WEST SUSSEX COUNTY COUNCIL CONSULTATION

TO:	Arun District Council FAO: Simon Davis
FROM:	WSCC - Highways Authority
DATE:	26 September 2019
LOCATION:	Evergreens, Level Mare Lane, Fontwell, PO20 3SA
SUBJECT:	AL/76/19/PL Demolition of existing dwelling & erection of 3 bed replacement chalet dwelling.
DATE OF SITE VISIT:	N/A
RECOMMENDATION:	Advice
S106 CONTRIBUTION TOTAL:	N/A

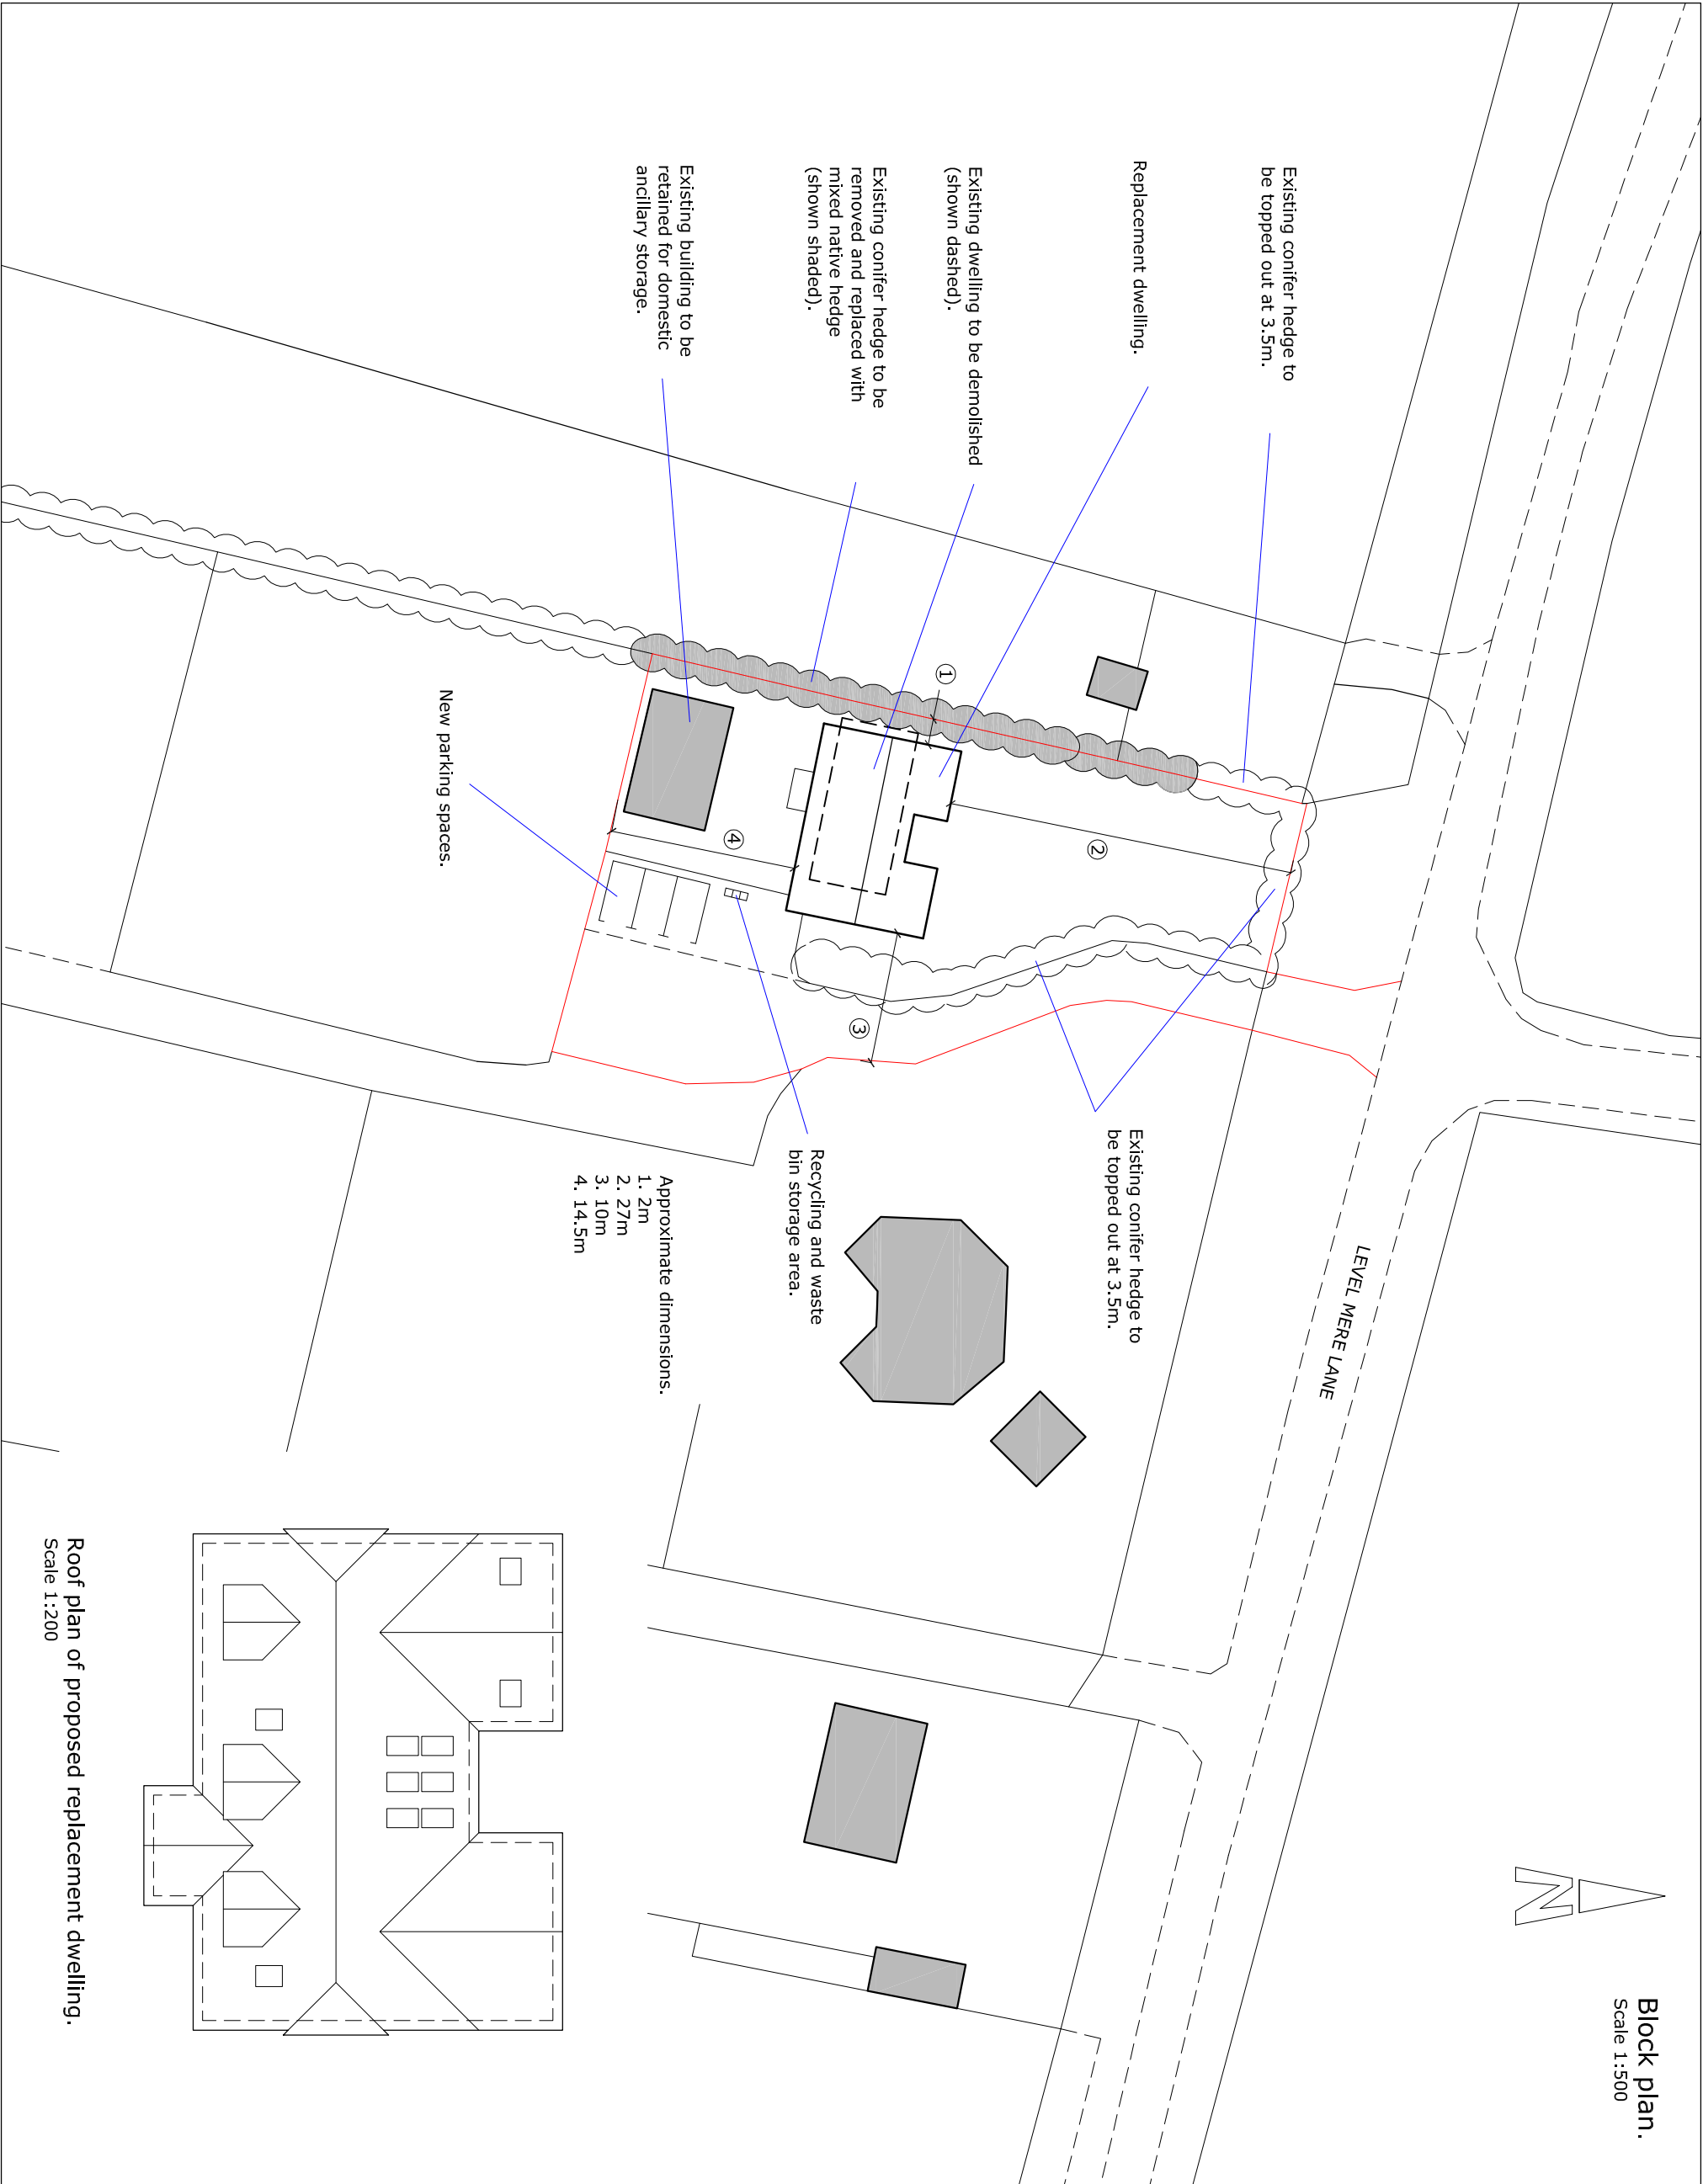
3 new parking spaces are proposed for this development. The WSCC Car Parking Demand Calculator has indicated that a dwelling of this size in this location would require 3 car parking spaces. Therefore the proposed parking provision is considered sufficient to meet the anticipated demand of the property.

The parking spaces demonstrated in the plans have approximate dimensions of 2.6m x 4.8m. This meets the minimum specifications for single car bays set out in Manual for Streets (MfS). There is also sufficient space for on-site turning to be achievable, allowing vehicles to exit onto Level Mare Lane in a forward gear.

4 existing cycle parking spaces are to be retained, although it was unclear from the plans where there are. The LHA assumes these are within the ancillary storage building to the south of the proposed dwelling. The inclusion of secure and covered cycle storage promotes the use of sustainable alternative modes of transport to the private car.

No part of the development shall be first occupied until the car parking has been constructed in accordance with the approved site plan. These spaces shall thereafter be retained at all times for their designated purpose.

No part of the development shall be first occupied until covered and secure cycle parking spaces have been provided in accordance with plans and details submitted to and approved by the Local Planning Authority.
